**Bramford To Twinstead
Examining Authority Questions to AONB Partnership for DL3 (31 Oct 2023)**

TITLE
 2.11.5 DESIGN AND LAYOUT PLANS: DEDHAM VALE EAST CABLE SEALING END COMPOUND

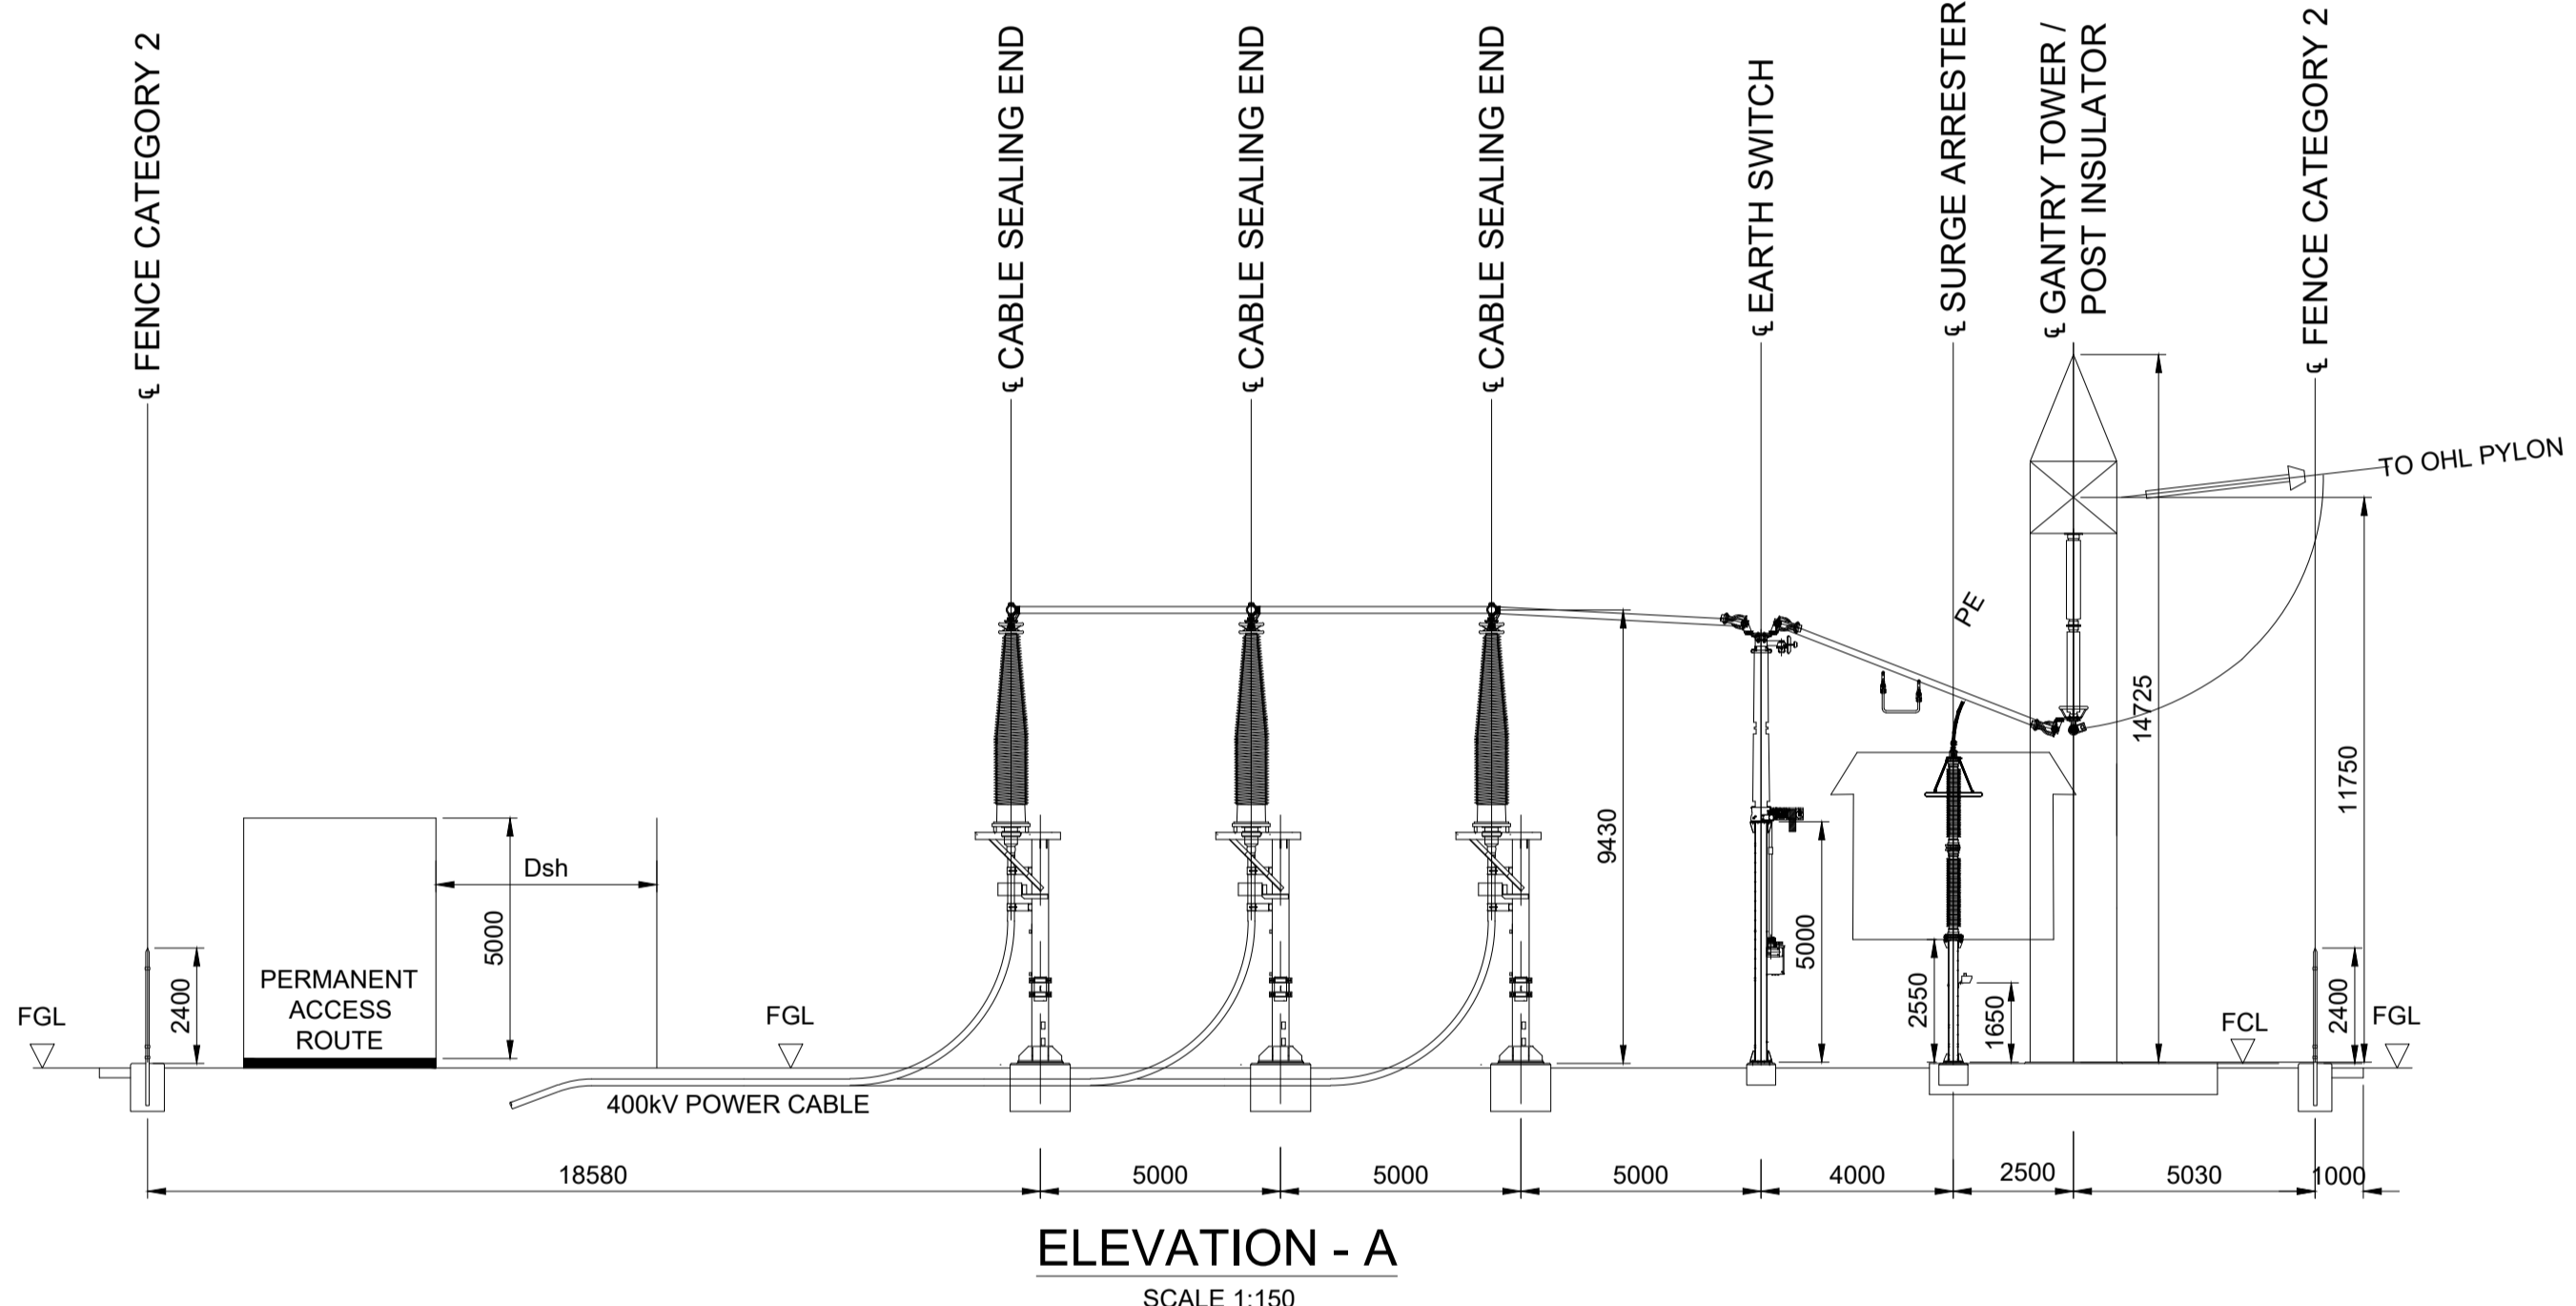
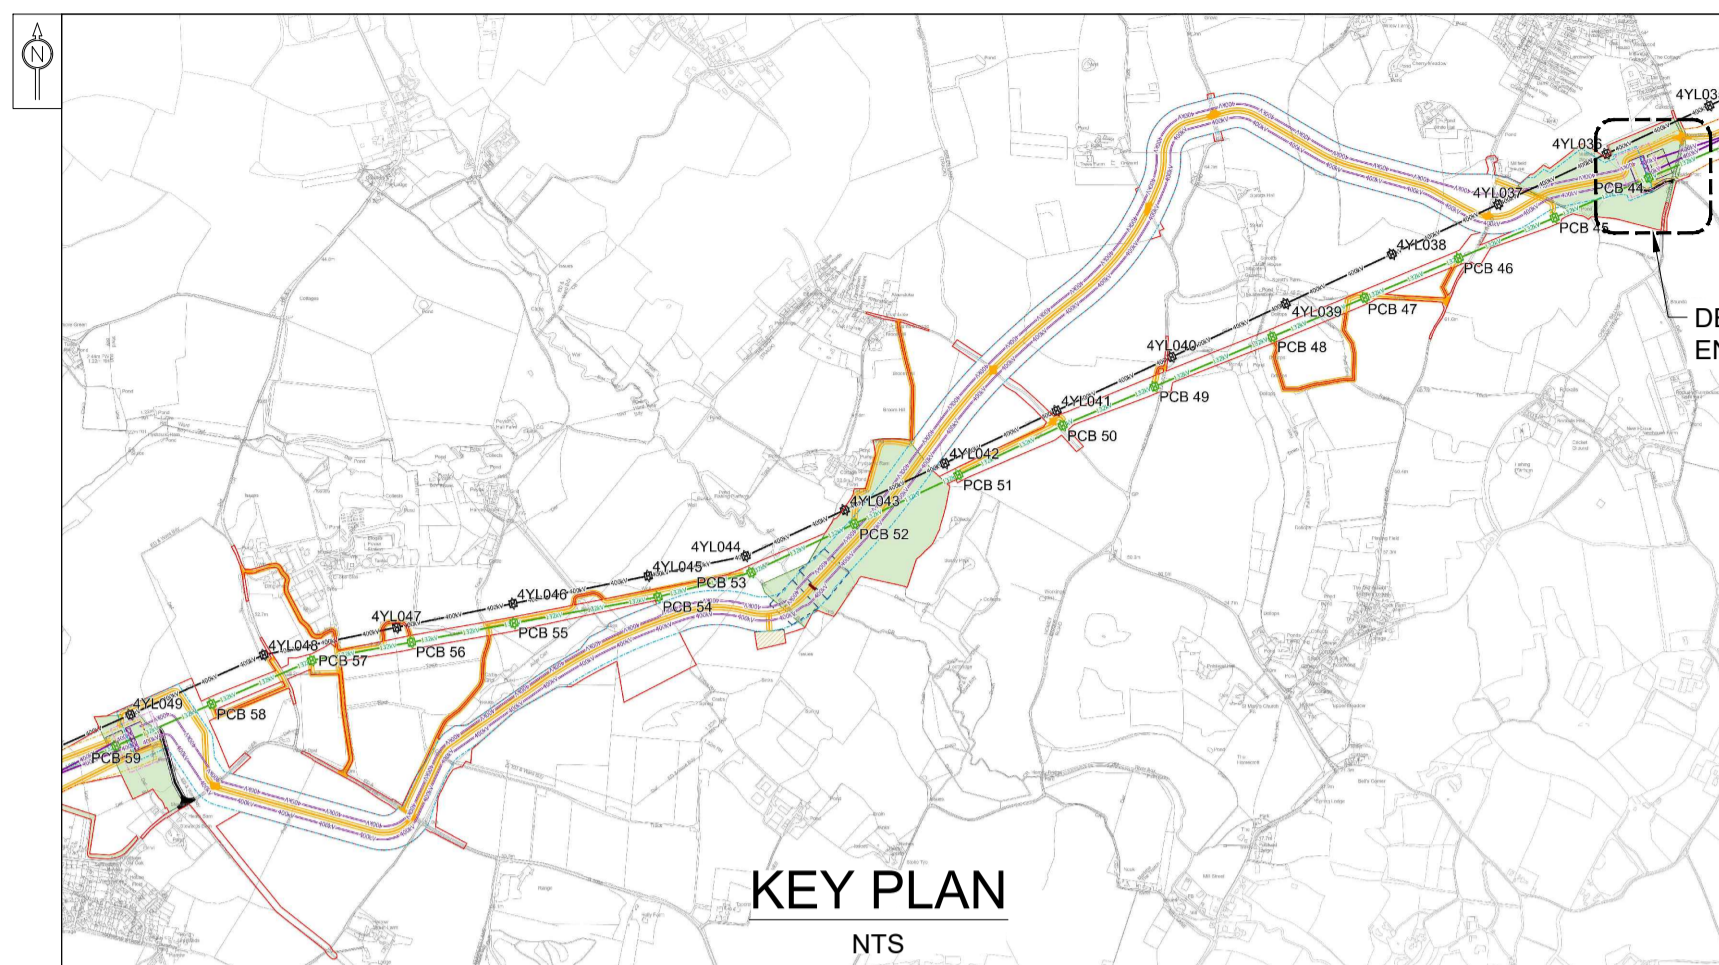
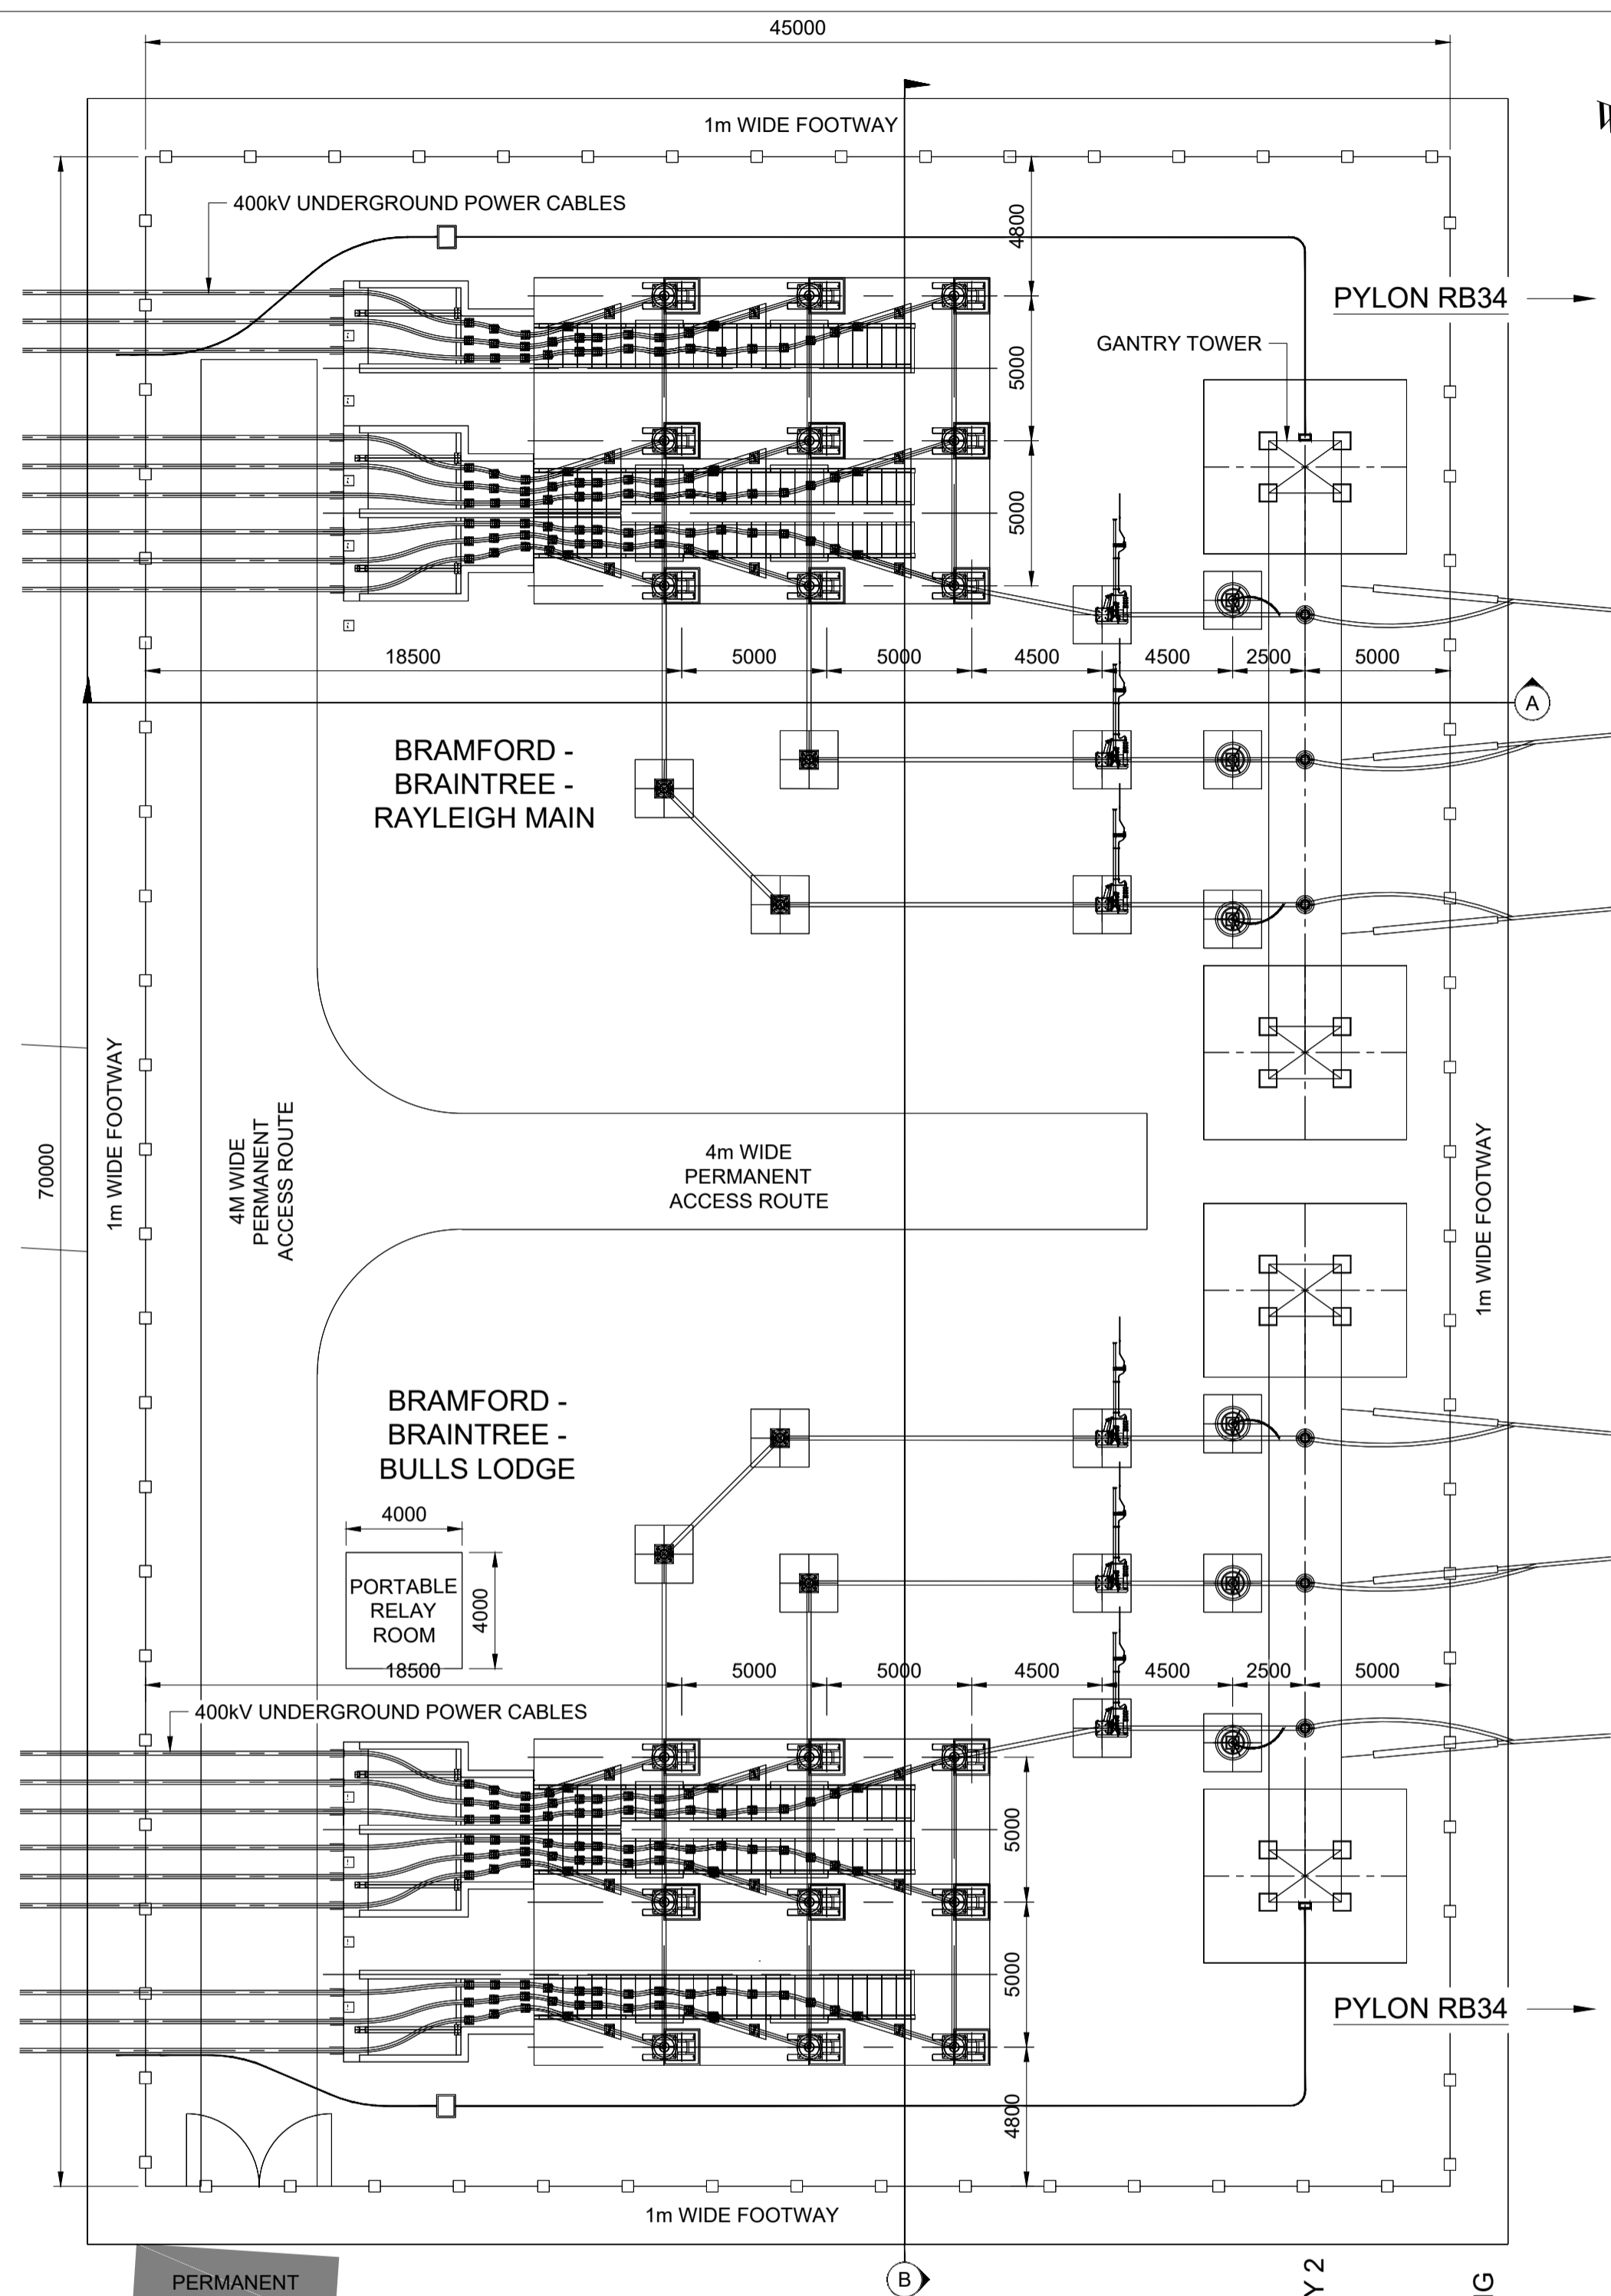
<p>[REP1-025] Section 2.13: The Dedham Vale AONB and Stour Valley Partnership considers that the proposed revised location of the Dedham Vale East Cable Sealing End Compound will not cause significant harm to the AONB but that local receptors should be considered.</p> <p>[REP1-025] Section 3.9: The Dedham Vale AONB and Stour Valley Partnership consider that the applicant is underplaying the assessed impacts on the AONB in the statement from this document:</p> <p><i>The natural beauty indicators of the AONB - notably scenic quality, relative wildness and relative tranquillity would be adversely affected. Given however that these significant adverse effects would be experienced relatively locally within approximately 1km of the LoD and would be short term, temporary and mainly reversible, it is not considered that the overall integrity of the AONB would be affected.</i></p> <p>It considers that the nationally designated landscape is a single entity and as such impact to part of the AONB is an impact to the entity of the AONB.</p> <p>The Dedham Vale AONB and Stour Valley Partnership broadly welcome the undergrounding of cables through the nationally designated landscape, noting the care required to minimise negative impacts on important habitats and archaeological assets. It notes that the driver for undergrounding is national policy (para 2.9.20 National Policy Statement for Electricity Networks Infrastructure (EN-5)) and it should not be seen as compensation for the negative impacts of the scheme during construction, particularly on the natural beauty indicators of scenic quality, relative wildness and relative tranquillity.</p>
